**APPLICATION NO:** 24/00036/FUL/ADDINF  
**DESCRIPTION:** Proposed erection of conservatory.  
**LOCATION:** 182 Juniper Bracknell Berkshire

I am in receipt of your planning application in respect of the above proposal. Before the application can be validated, the following matters require attention:-

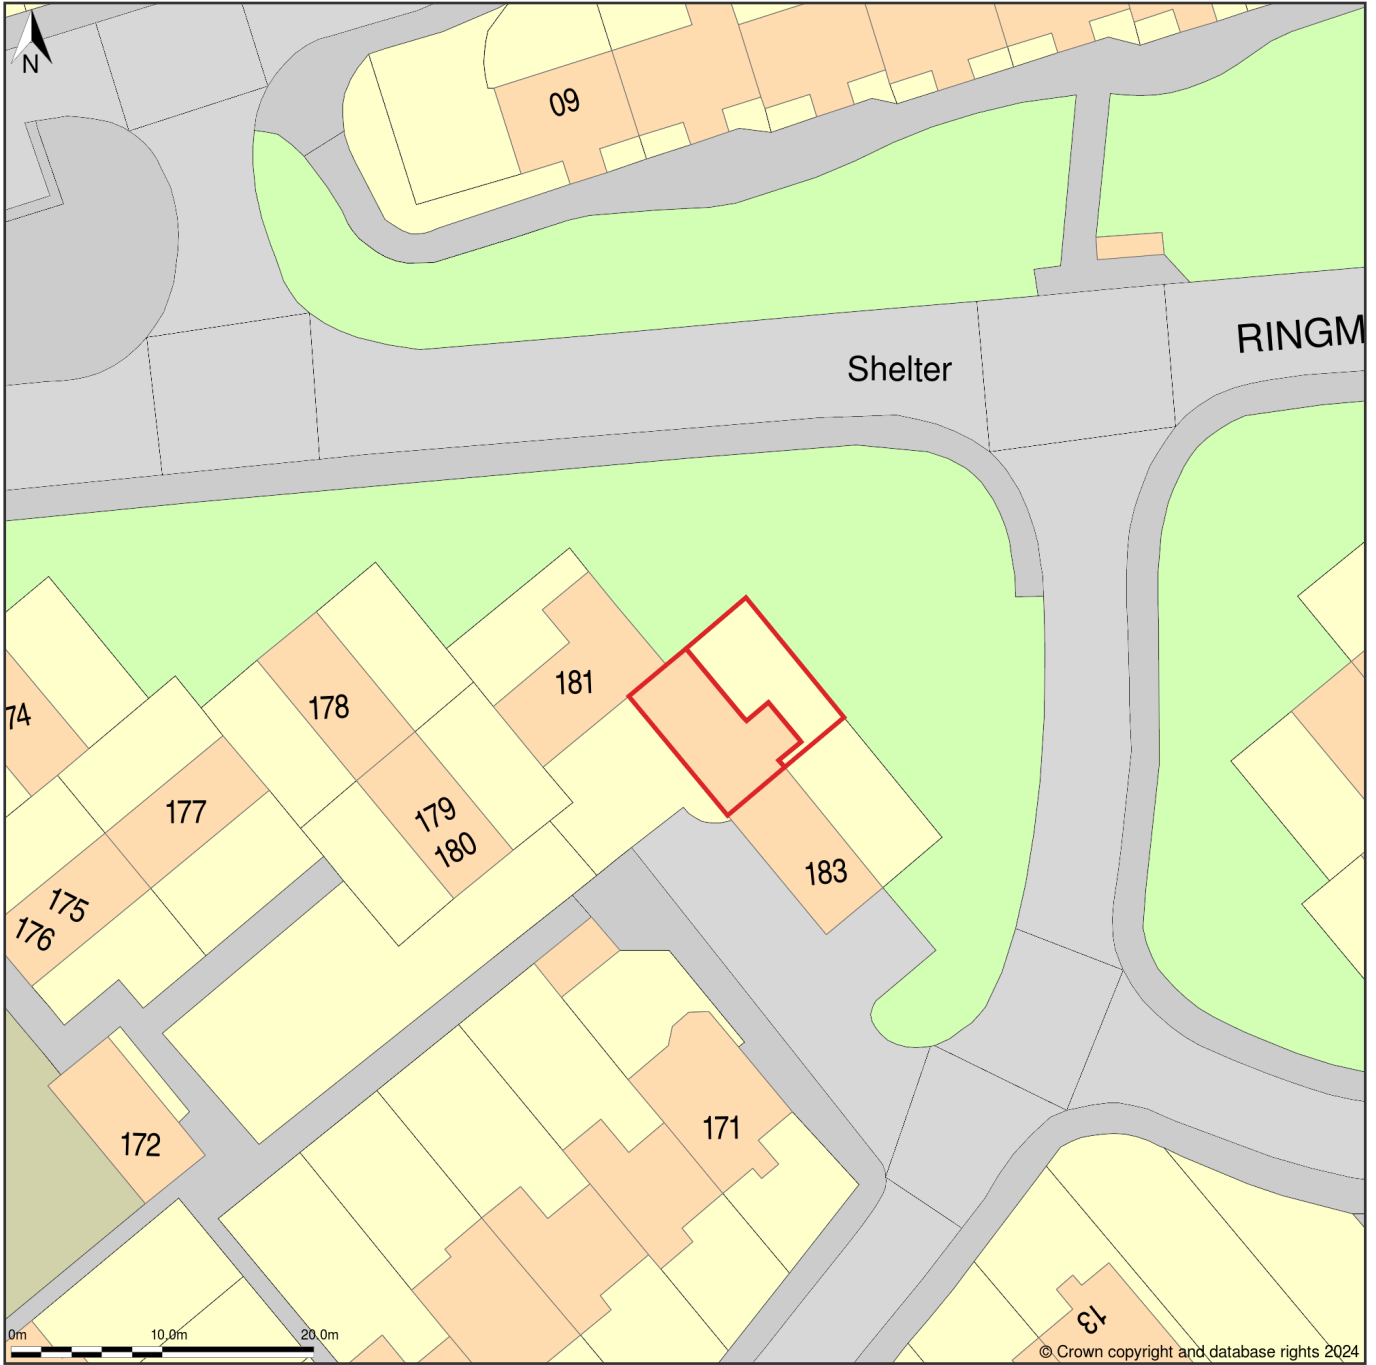
- 1 The site plan and location plan are not to scale. Please provide the site plan at a scale of 1:500 and the location plan at a scale of 1:1250.
- 2 Please provide existing floor plans and elevations at a scale of 1:100.
